1 December 2021

## **SECTION 4.55(1A) MODIFICATION APPLICATION - SSD-10375 PITT STREET NORTH OVER STATION DEVELOPMENT**

This section 4.55(1A) Modification Application has been prepared on behalf of Pitt Street Developer North Pty Ltd (**the Applicant**) to amend SSD-10375 which applies to the Pitt Street North Over Station Development Stage 2 (**PSN OSD**) at 252 Pitt Street, Sydney.

SSDA
GENERAL ARRANGEMENT ELEVATION
WEST ELEVATION - PITT STREET

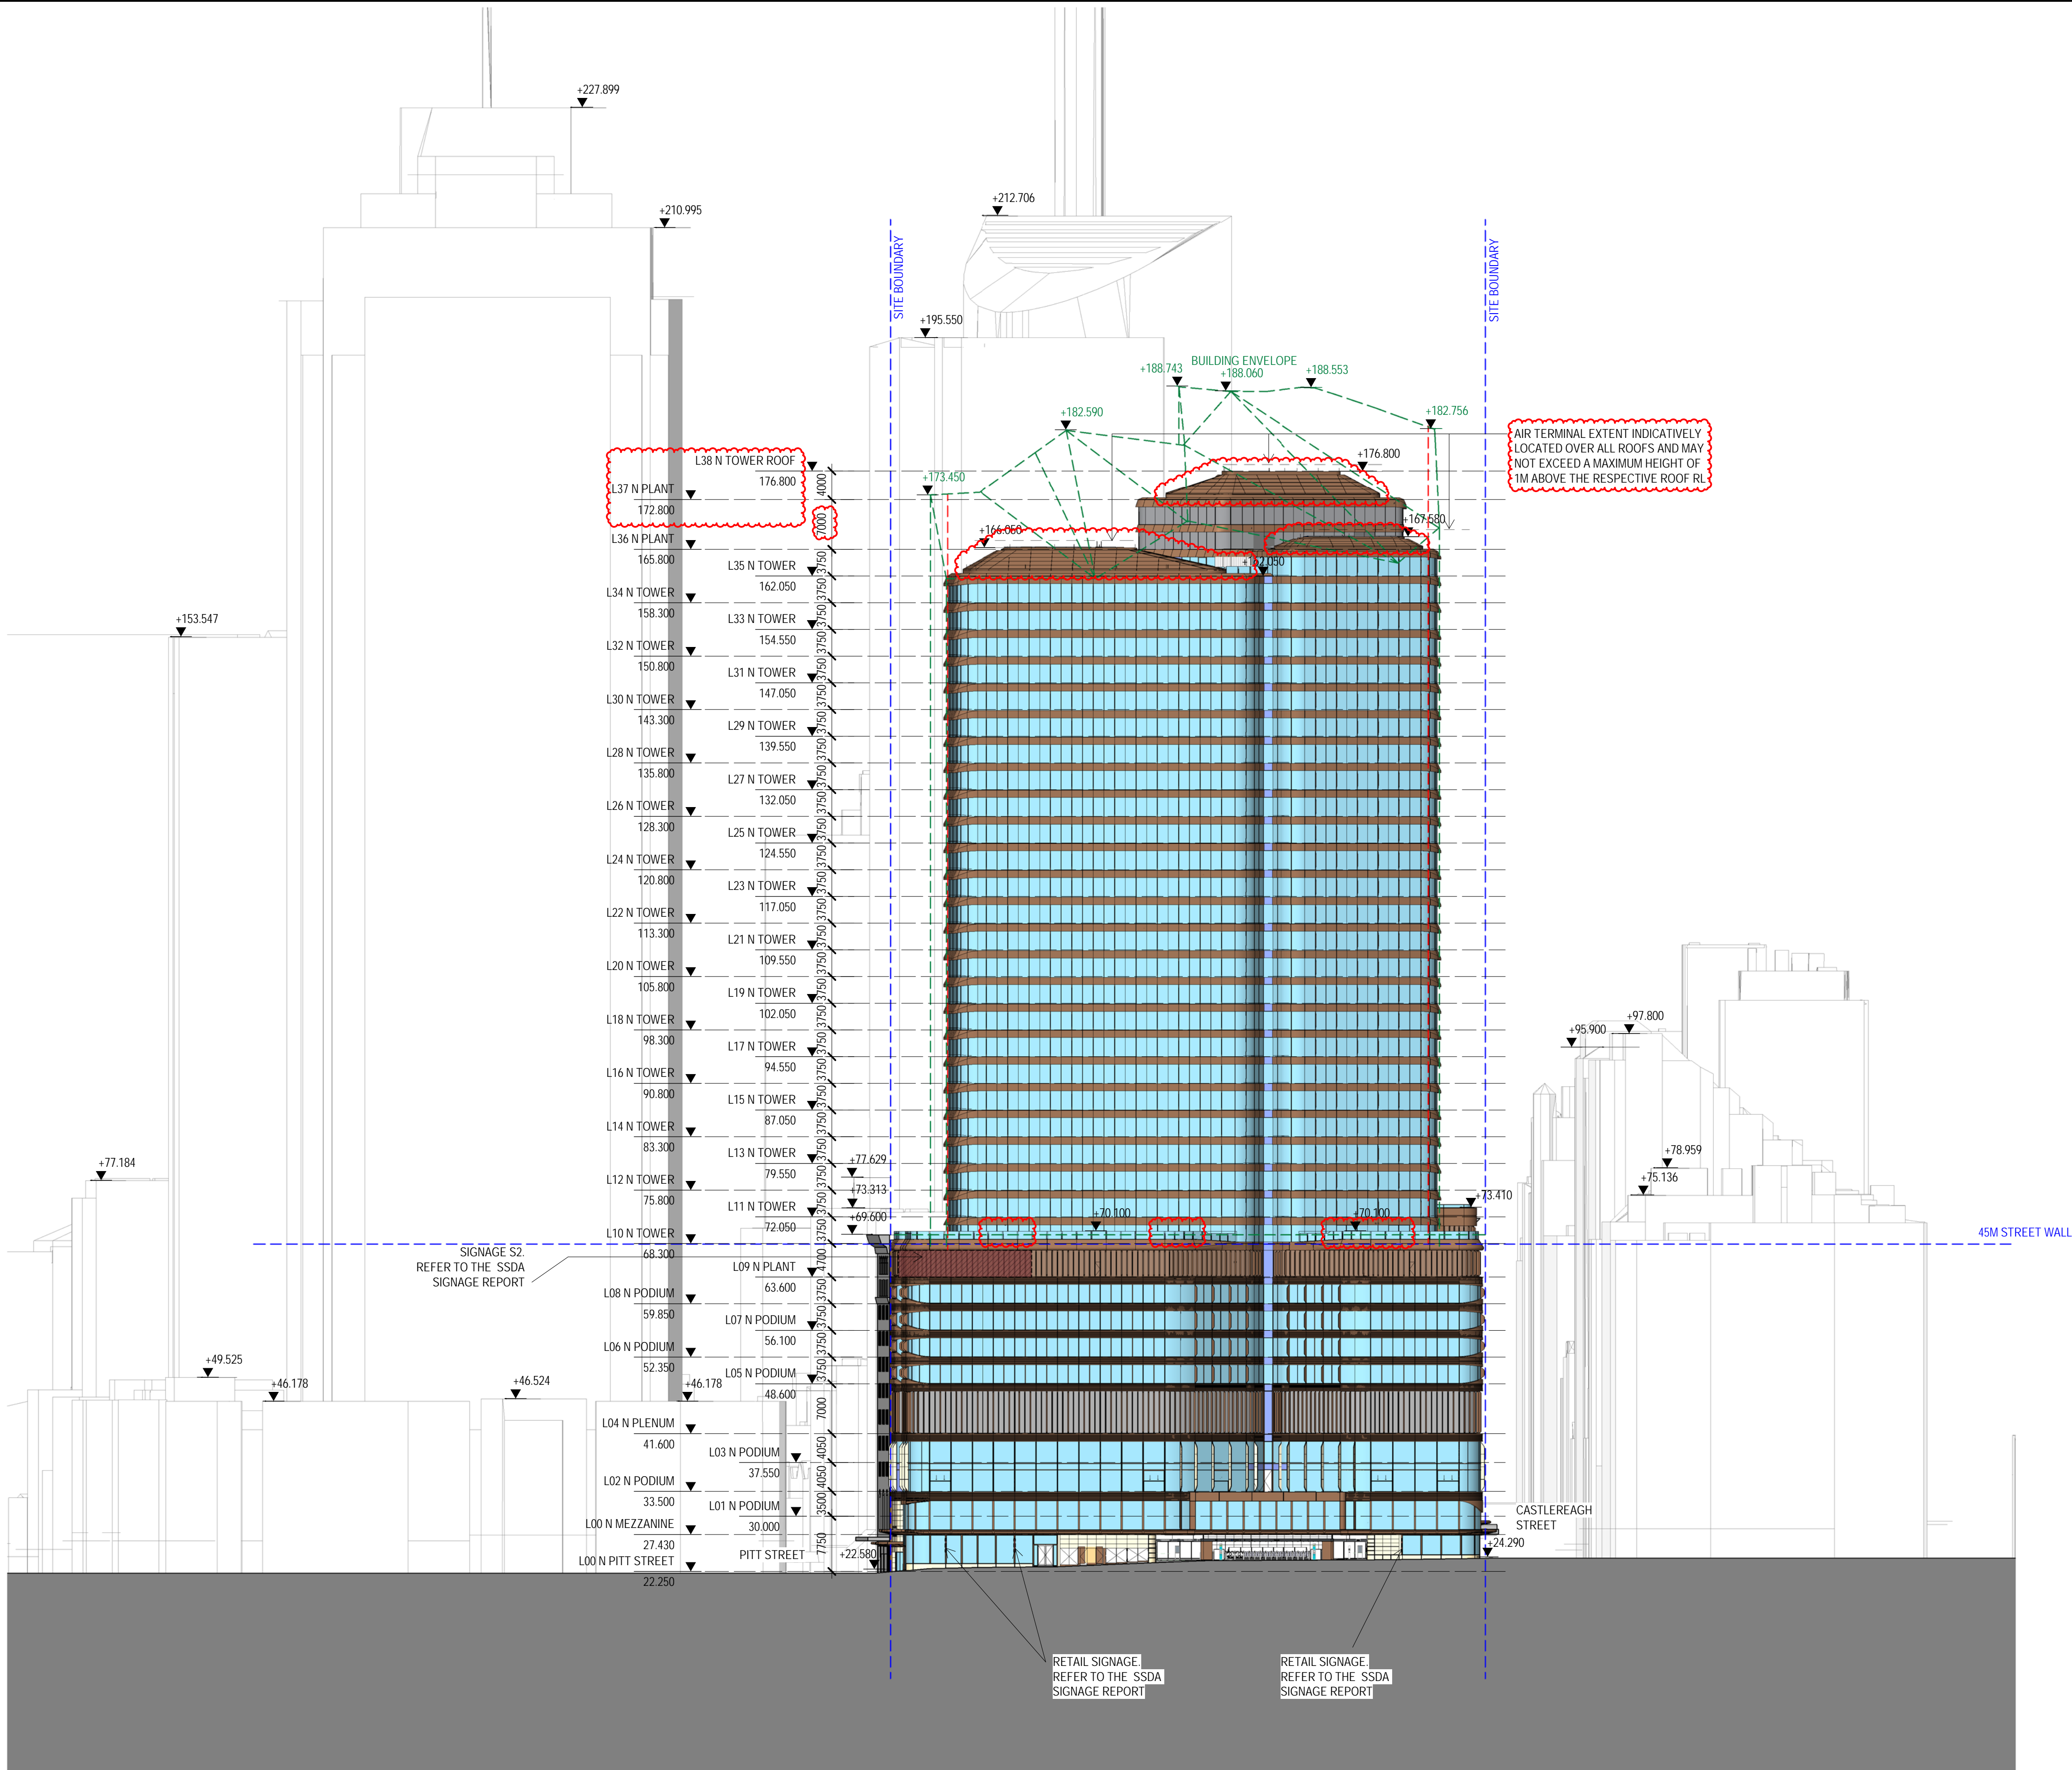
A correction has been made to the podium façade (level 5 through to level 9) on the eastern and western elevations to accurately show the corrugation detailing. This change is a graphical fix as illustrated in **Figure 7** and **Figure 8**.

The elevations of these facades have also been revised to reflect the change in terrace door opening widths as discussed further in **Section 2.3**.

The north western façade of the OSD podium was obscured in the approved General Arrangement Elevation West Elevation - Pitt Street Plan (drawing SMCSWSPS-FOS-OSN-AT-DWG-960001) as illustrated in **Figure 10**.

As part of this modification application it is proposed to include an additional plan General Arrangement Elevation North Western Façade (North – South Section) (SMCSWSPS-COX-OSN-AT-DWG-960005) with details of the secondary western façade as illustrated in **Figure 11**.

SOUTH ELEVATION - PARK STREET

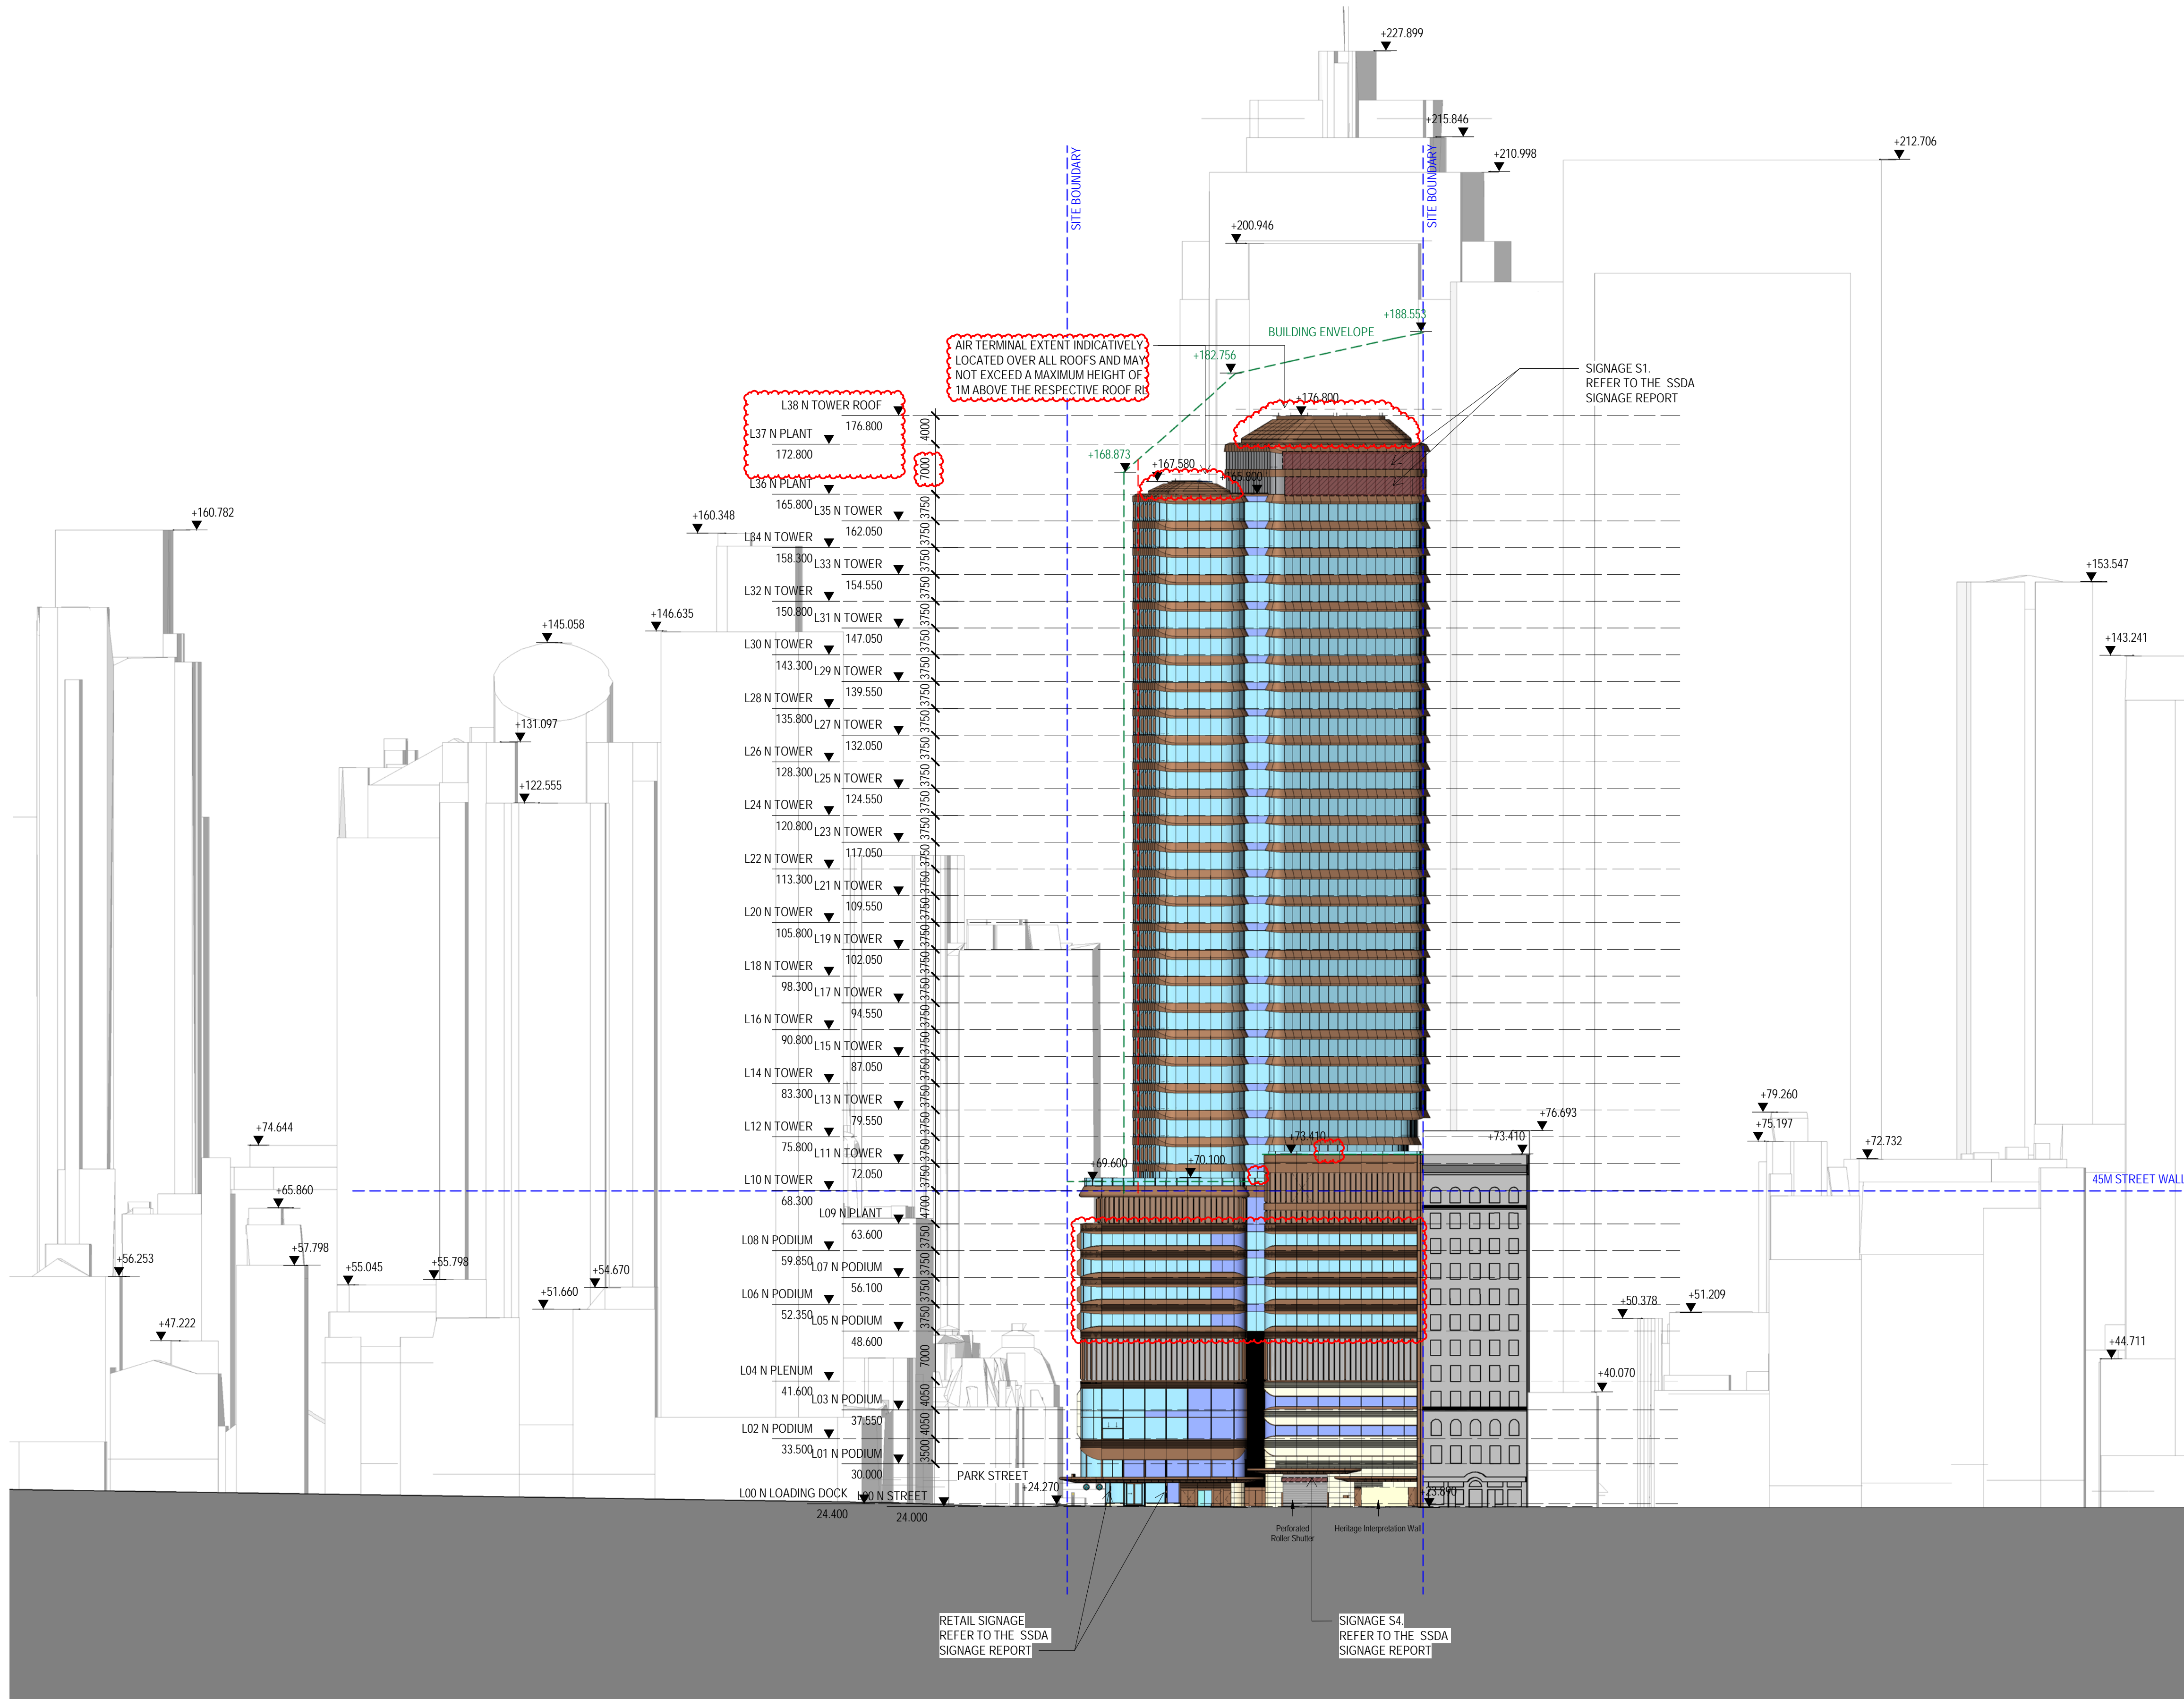
A correction has been made to the south western tower façade (level 35) to show fluted glazing adjacent to the amenities. A correction has also been made to the south western roof detailing, this change is a graphical fix as illustrated in **Figure 9**.
